Approval of details reserved by condition imposed under WA/18/19/PL relating to conditions 12-schedule of materials & finishes, 15-Method Statement, 16-energy efficiency measures & 17-surface water drainage disposal system.

Land Adjacent 1 Orchard Way Fontwell Arundel BN18 0SH

Arun District Council have decided to **REFUSE details reserved by condition for the following reasons:**

Soakaway test results

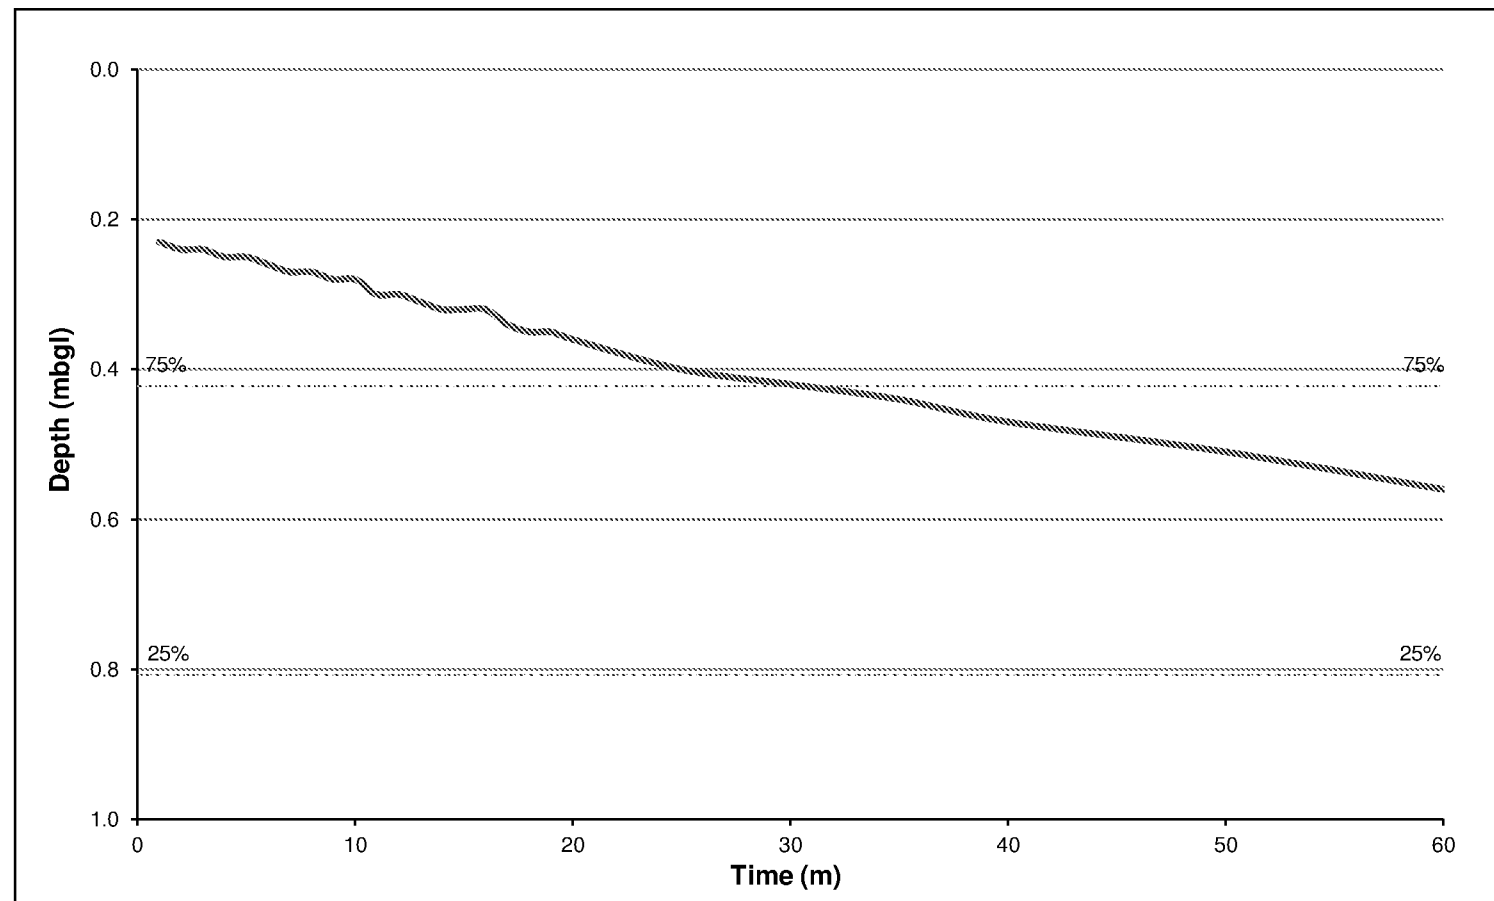
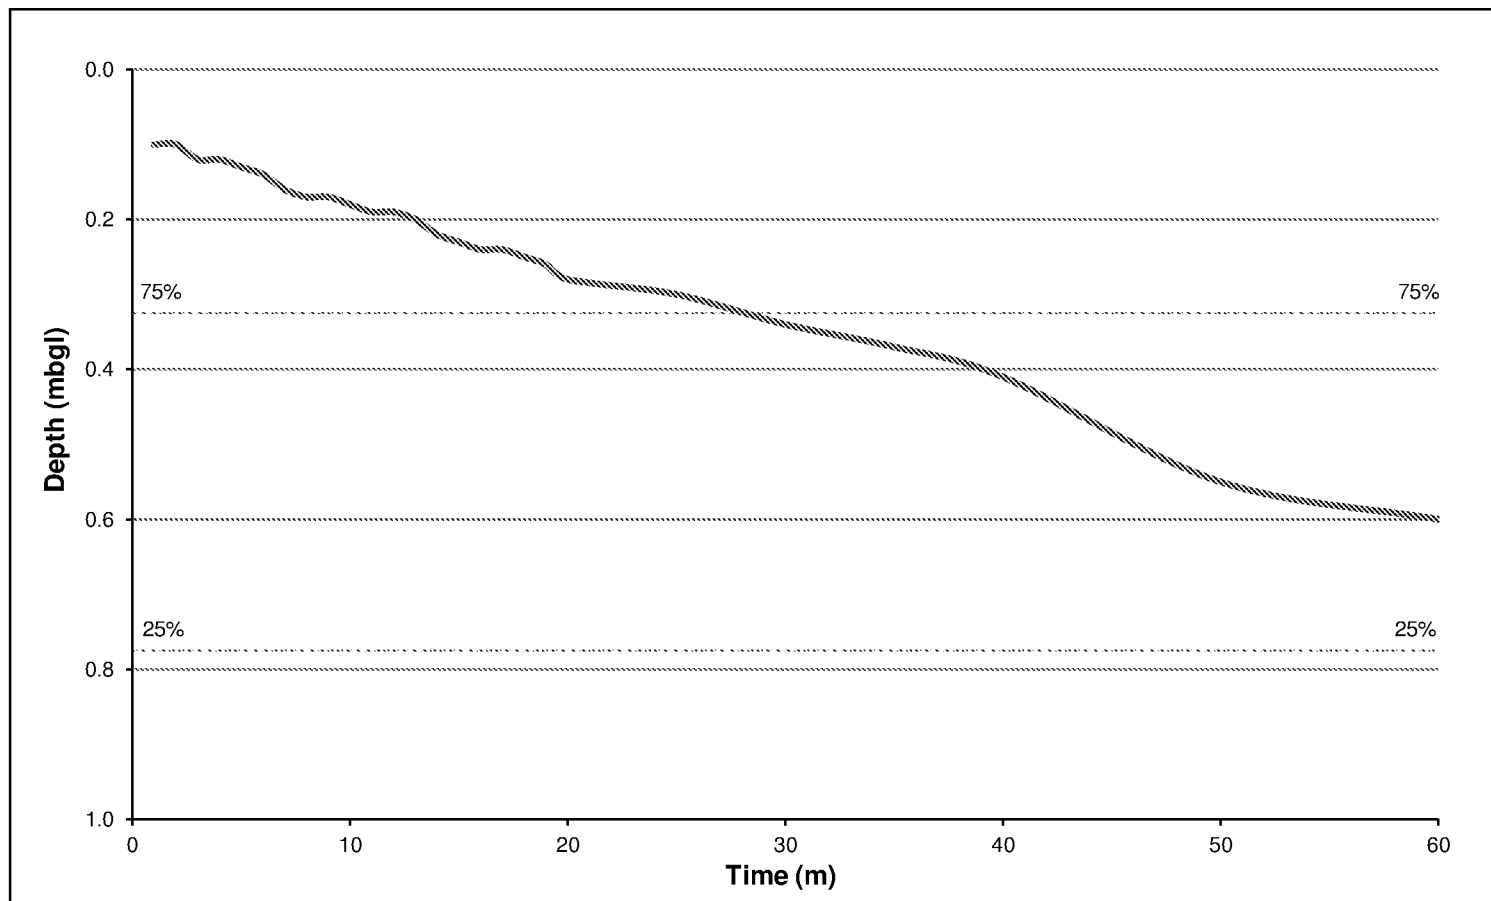
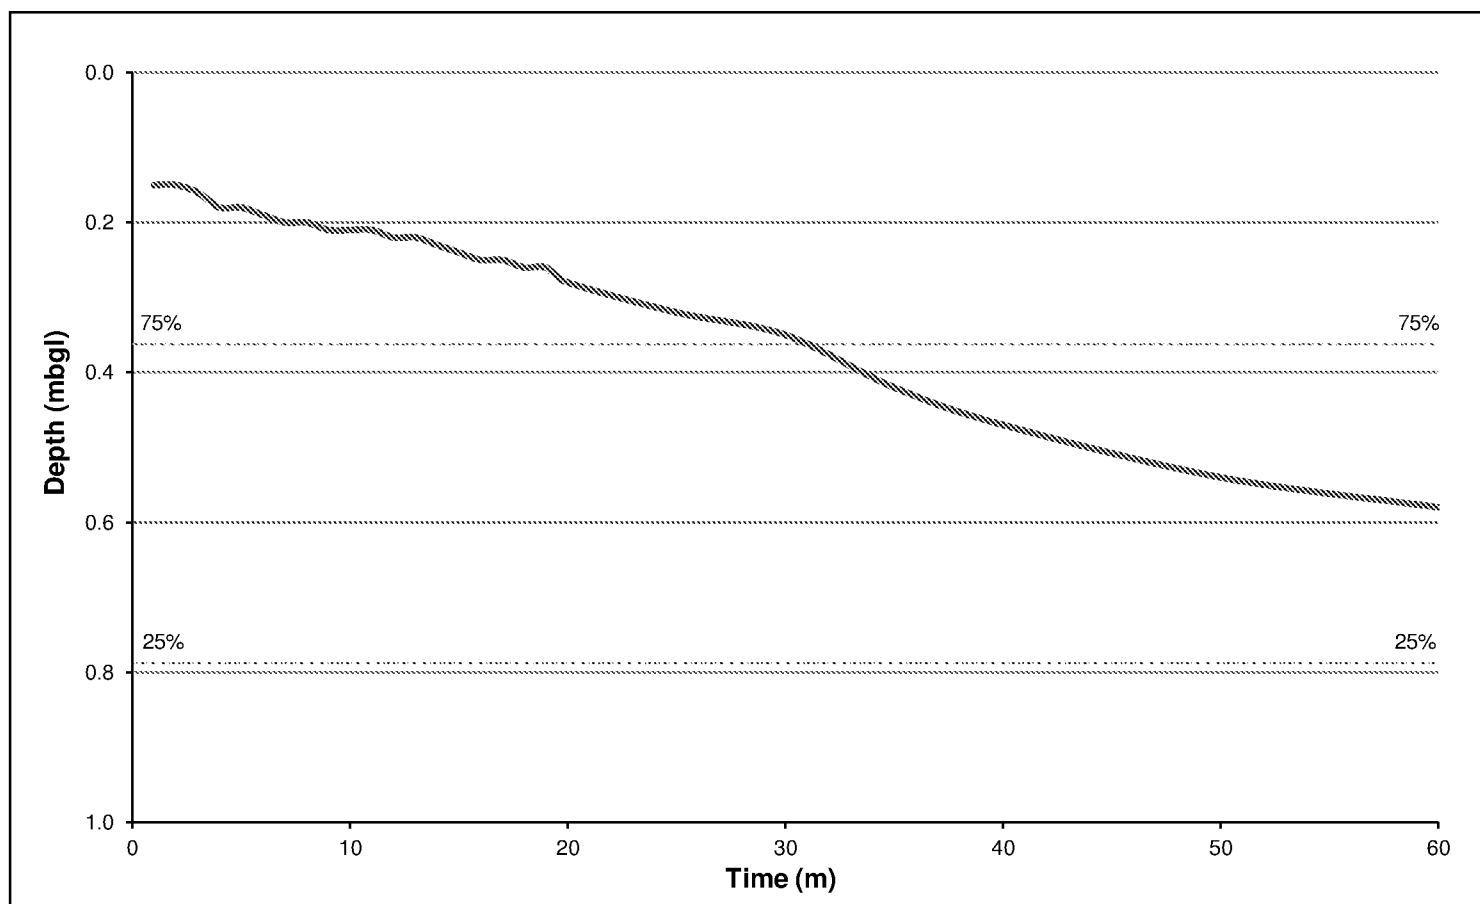
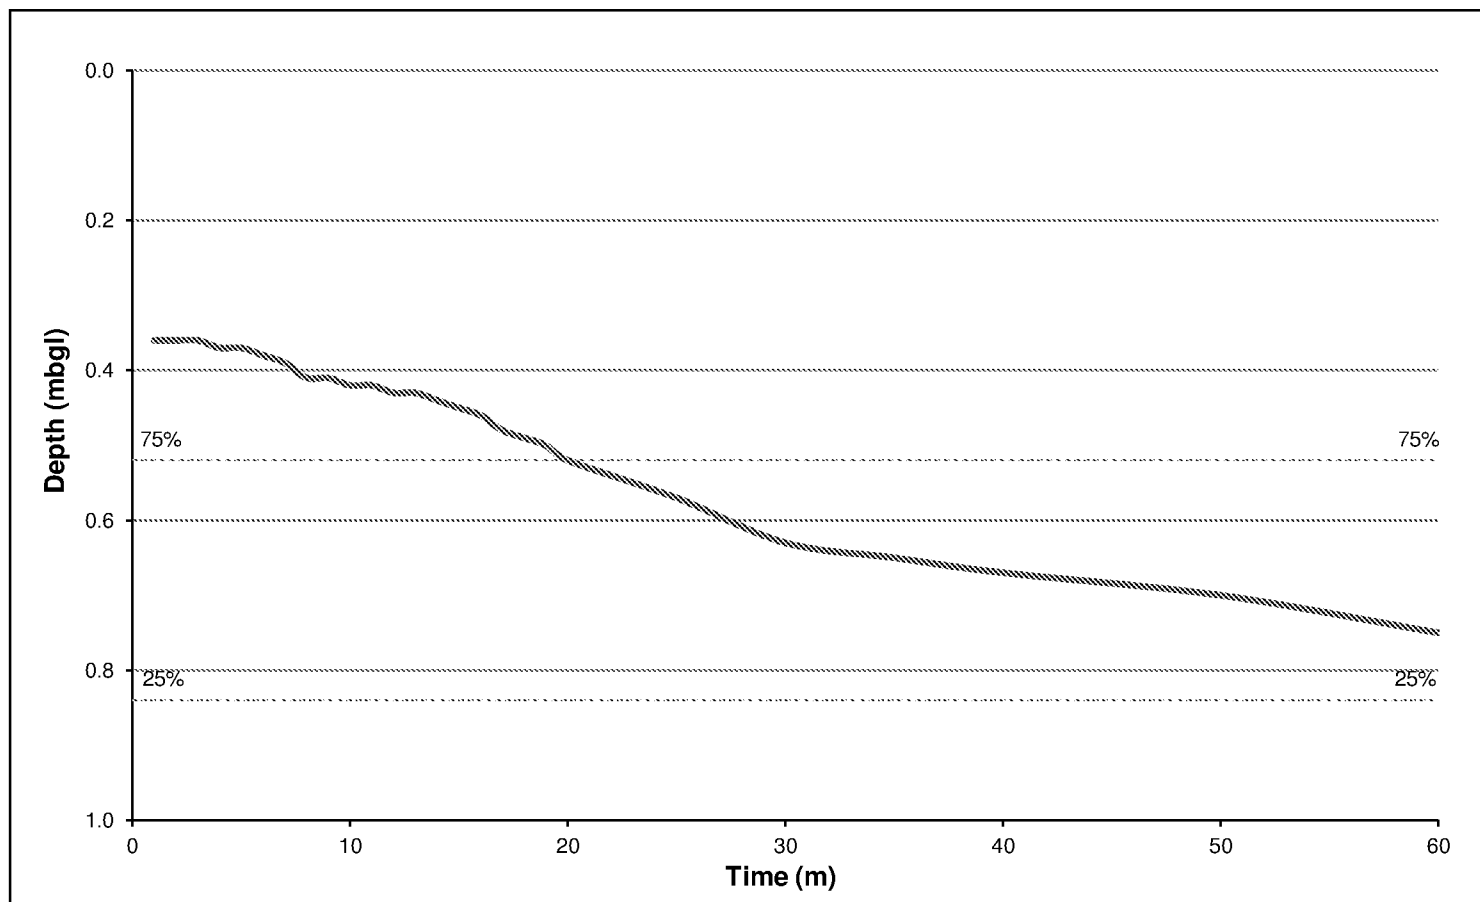
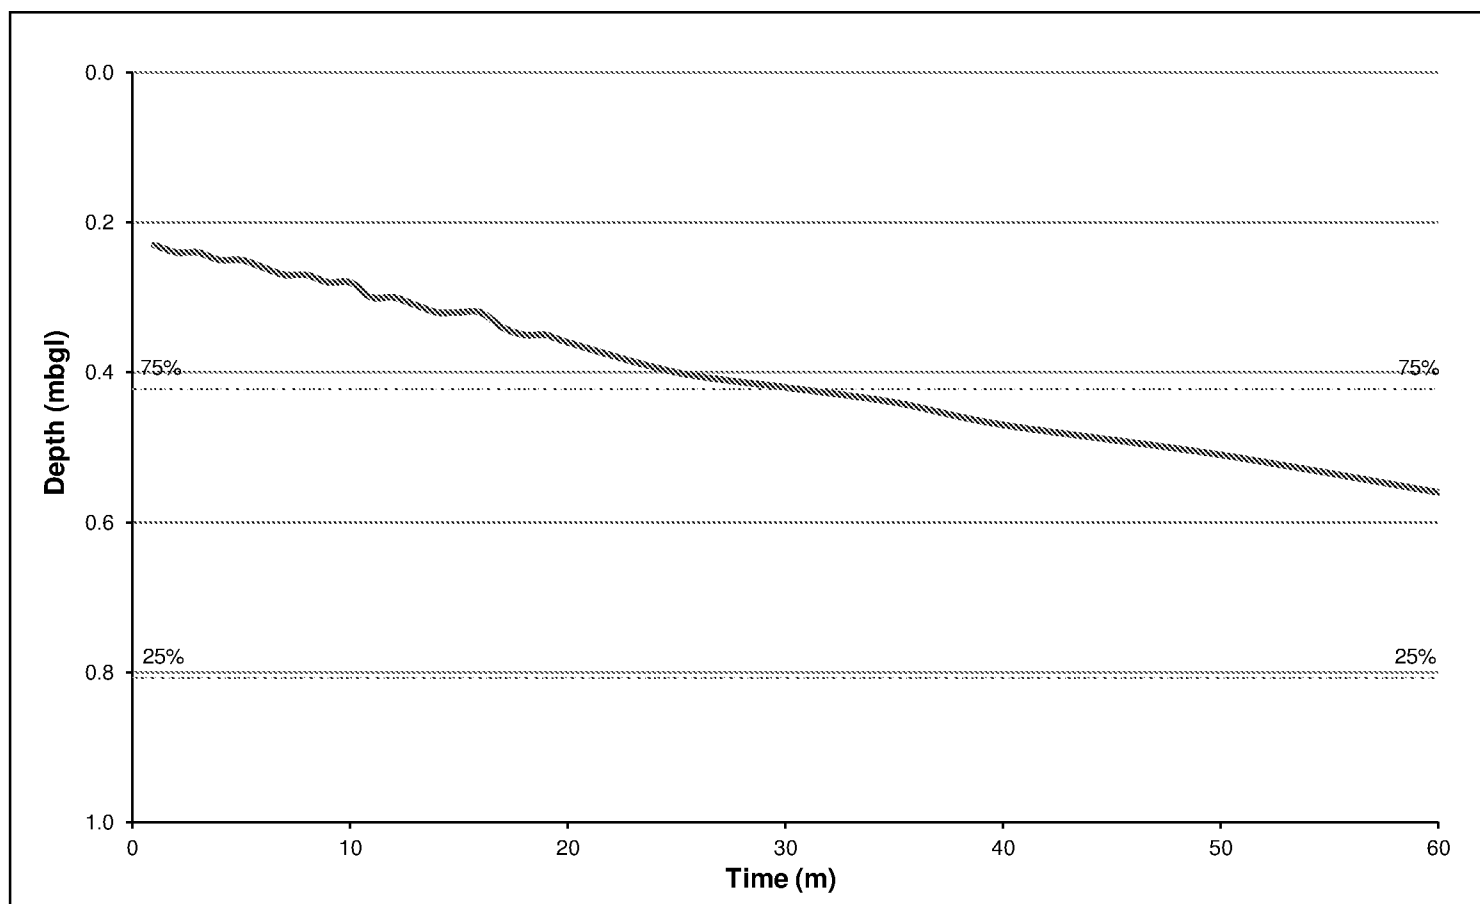
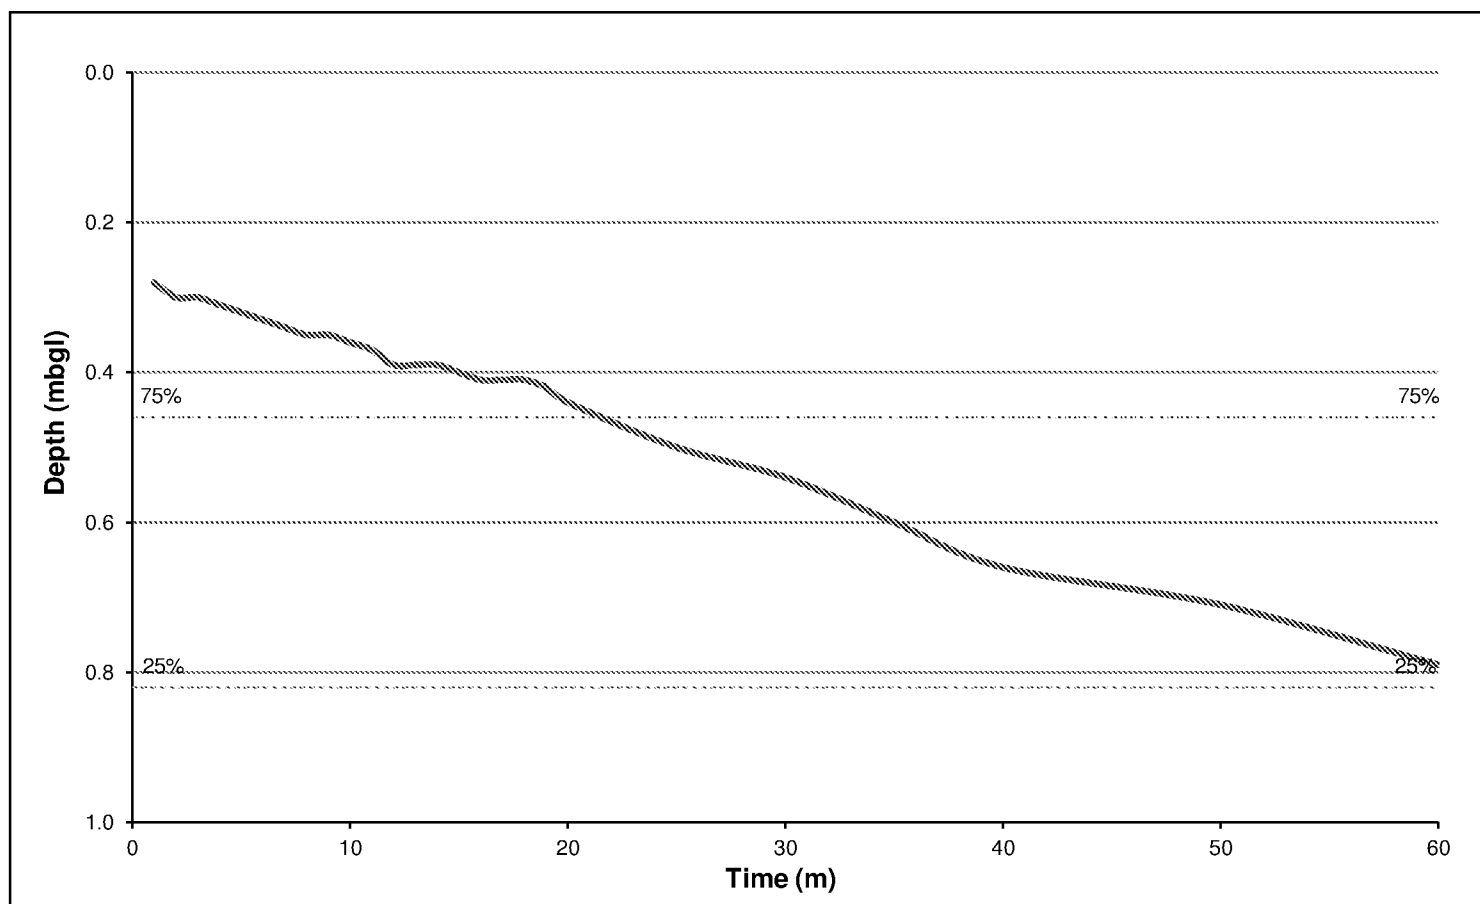
1. Please provide a clear list/table of exactly when and to what depth groundwater was observed.
2. Infiltration testing was only monitored for 60mins for each test after which point the results of almost every test was extrapolated. This is not in strict accordance with BRE DG 365 and no justification is given for the short duration of monitoring. I would like a justification for the methodology and expect a higher factor of safety (of at least 3) to be used in the calculations if these rates are to be used.
